Application No: EP/169/21/HH
Site Address: 11 Worthing Road East Preston BN16 1AT
Description of works: First floor rear extension including the installation of x2 side windows in existing gables and x3 front velux rooflights. Revision of EP/133/21/HH.

Thank you for your internet representation made on 24th January 2022 which has been recorded as an objection with the comments as follows:

Revisions A - new doors changed to a pitched roof
 11 WORTHING ROAD, EAST PRESTON
 Proposals 04 A
 Oct 2021

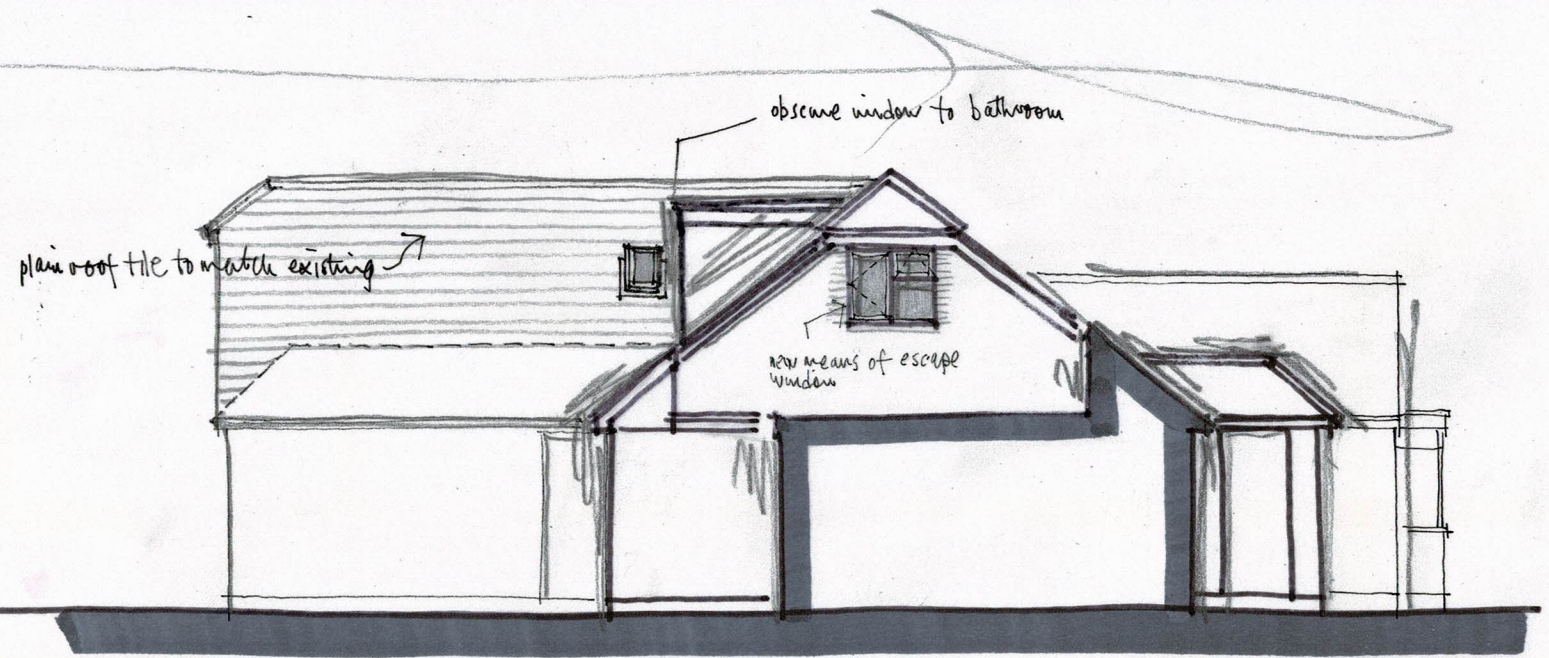
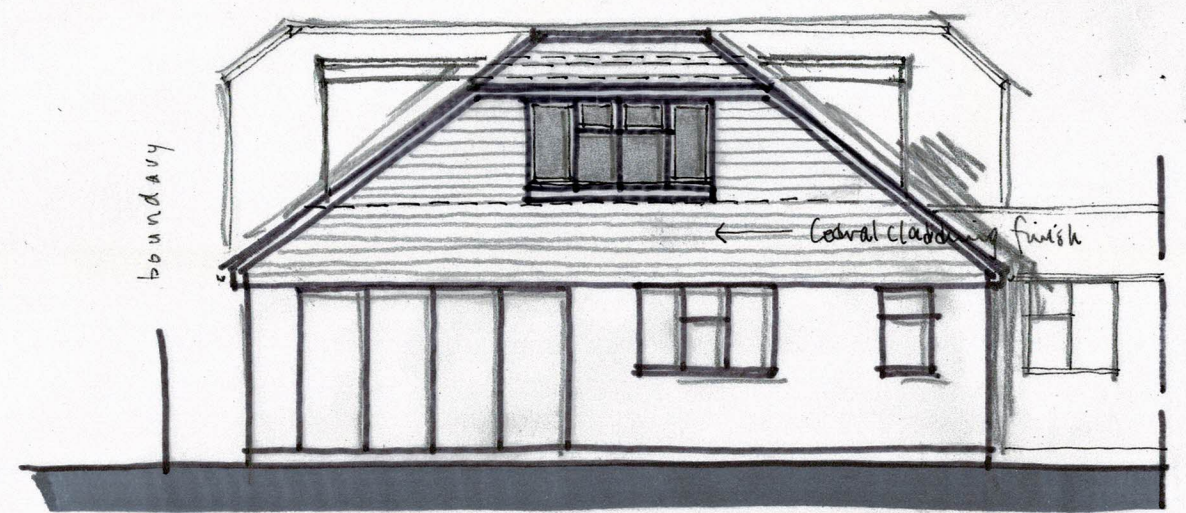
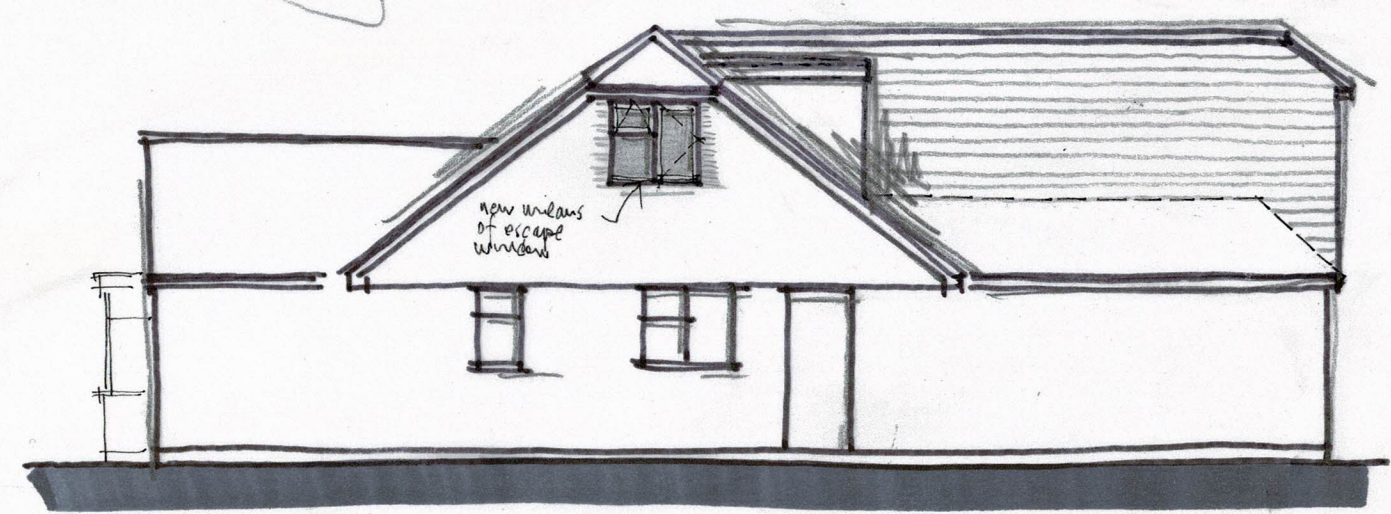
I write as Chairman of the East Preston and Kingston Preservation Society. This revised proposal does not meet the objections the Society made to the withdrawn application (EP/133/21/HH). It would still lead to an overdevelopment of an already much altered small semi-detached bungalow. The three street-facing rooflights would not fit in with neighbouring buildings, none of which has a front rooflight. The rear first floor extension, though of altered design, will stretch further back into the plot and would not appear integrated with or subservient to the original structure. The bulky first floor extension would be overbearing in appearance and visible walking in both directions up the street.

It would also further compromise the symmetry of the attached bungalow to the west. The proposed side windows, even if obscure glazed, would have to be fully opening, as means of escape - again to the detriment of the amenity of neighbouring properties. The Society therefore asks that this application be refused.
